Our ref: NH/2406328

Application Ref:
EN010128-000246

Cory Decarbonisation Project Development Consent Order (DCO) EN010128 Planning Application Norman Road, Belvedere, London, DA17 6JY
SECTION 56 PLANNING ACT 2008: WRITTEN REPRESENTATION OF NATIONAL HIGHWAYS LIMITED.

Figure 6 - Draft HGV Routeing Plan

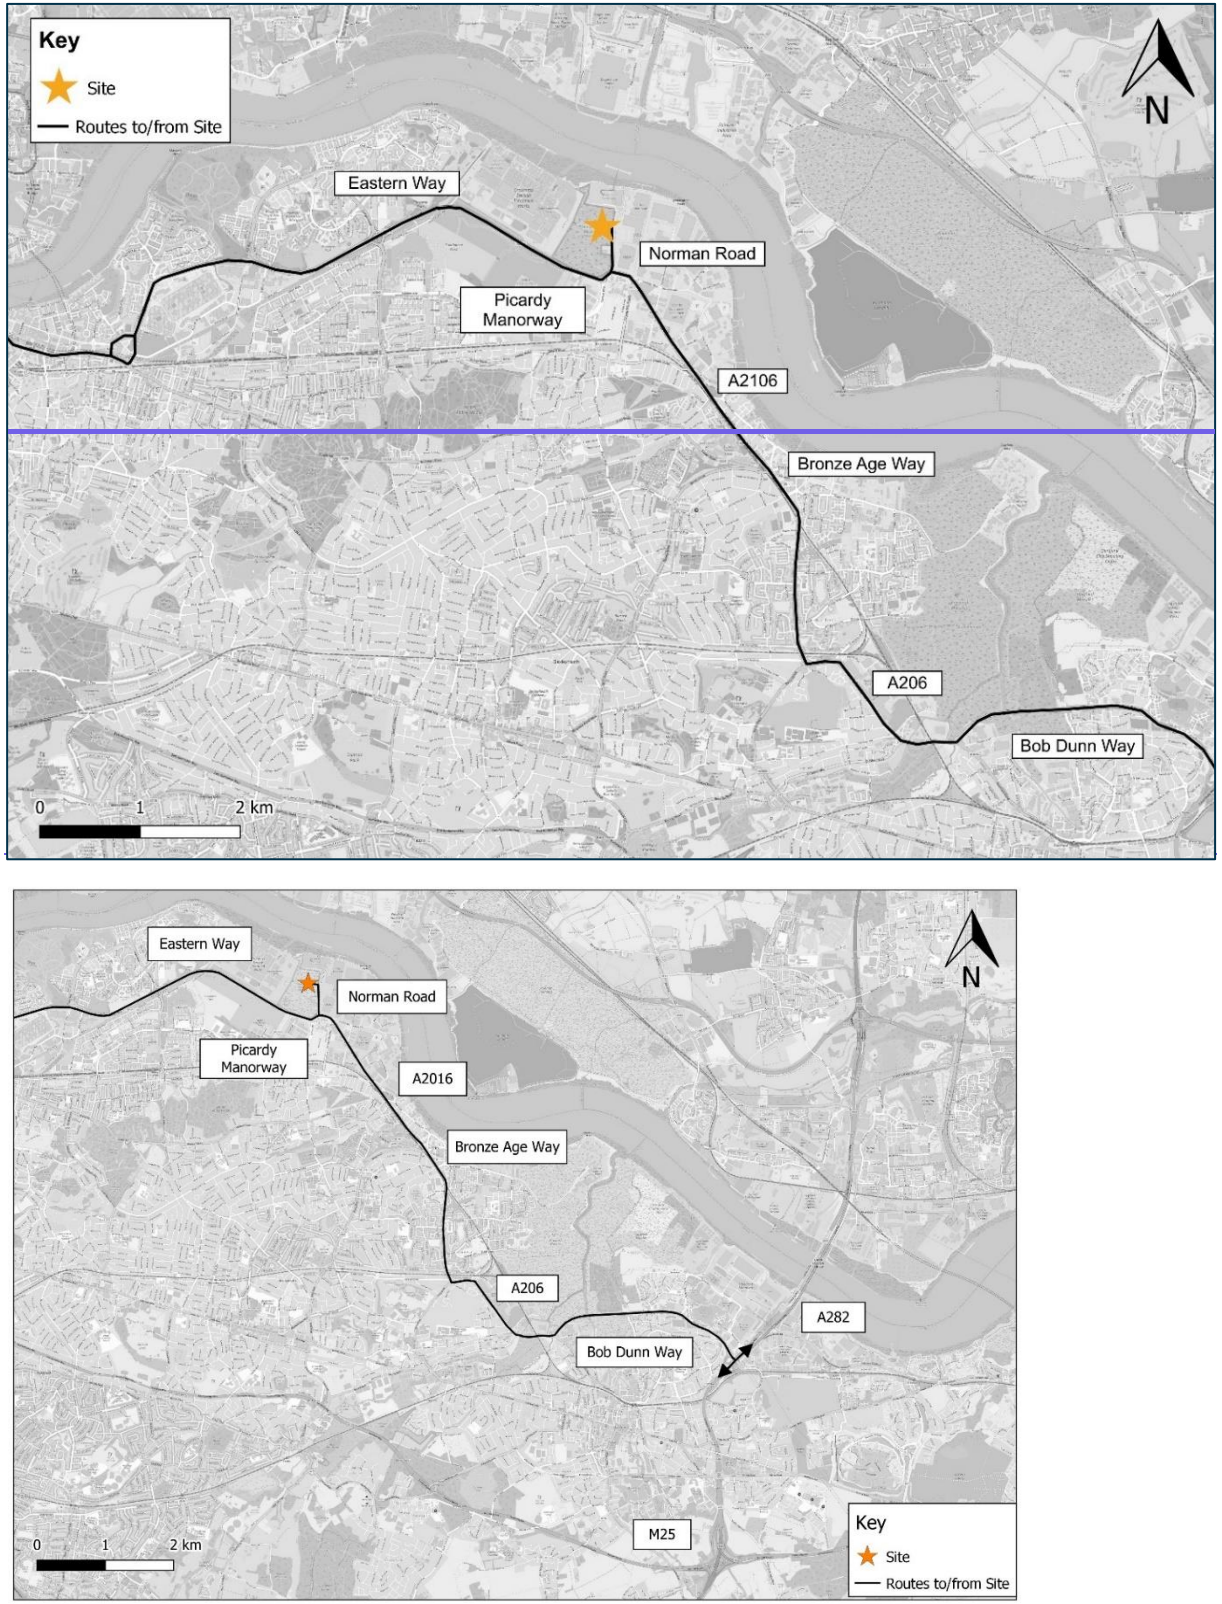
2. A Framework Construction Traffic Management Plan (FCTMP) has been prepared and submitted with the DCO application, but it is acknowledged that a full CTMP will be prepared post-determination, once contractor(s) have been appointed, secured by a DCO requirement. This full CTMP is likely to be the means by which National Highways can better understand the traffic impacts of the proposals on the SRN and ensure that mitigation measures are identified if necessary.

The Applicant should provide certainty that a full CTMP and a Construction Workers' Travel Plan will be submitted to and agreed with National Highways prior to on-site works commencing. As a statutory consultee, National Highways should have consideration of these documents regarding the impacts on the SRN to ensure they adequately address National Highways' concerns.
